CITY OF ALBUQUERQUE

Re: Burger King
7101 Lomas Blvd. NE
30-Day Temporary Certificate of Occupancy
Transportation Development Final Inspection
Architect's Stamp dated 01-31-23 (J19-D052)
Certification dated 12-21-23

BICYCLE RACK

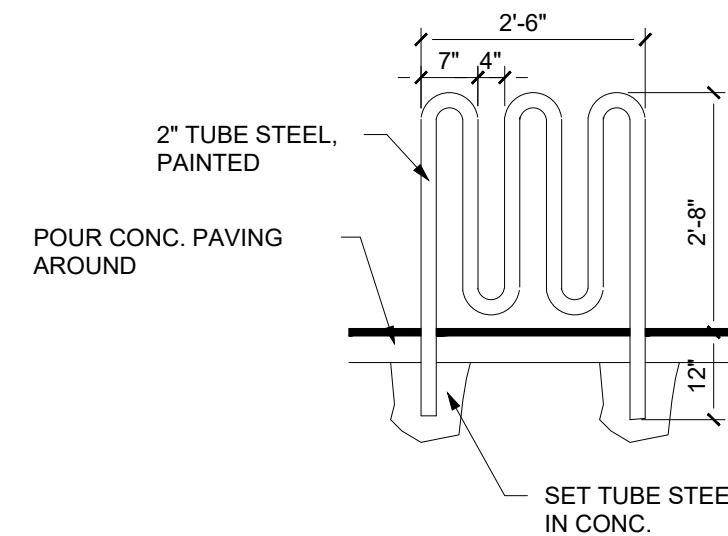
1. Provide ADA parking spaces signs. The ADA accessible parking sign must have the required language per 66-7-352.4C NMSA 1978 **"Violators Are Subject to a Fine and/or Towing."** Please call out detail and location of signs.
2. provide Motorcycle parking space sign.
3. Anchor down the bike rack.
4. Keynote 18 "DO NOT ENTER" & "ONE WAY" signage is missing.
5. Please fix the installation of the truncated domes at the east leg of the site access off Lomas.

G RAMP STANDARDS

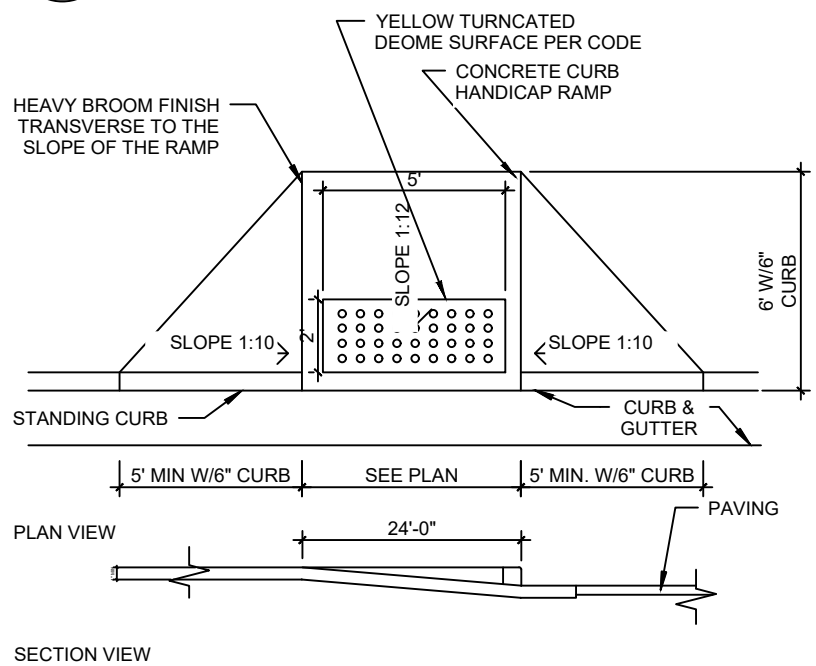
6. Tripping hazard: please fix the ADA ramp at the site access off Louisiana Blvd.
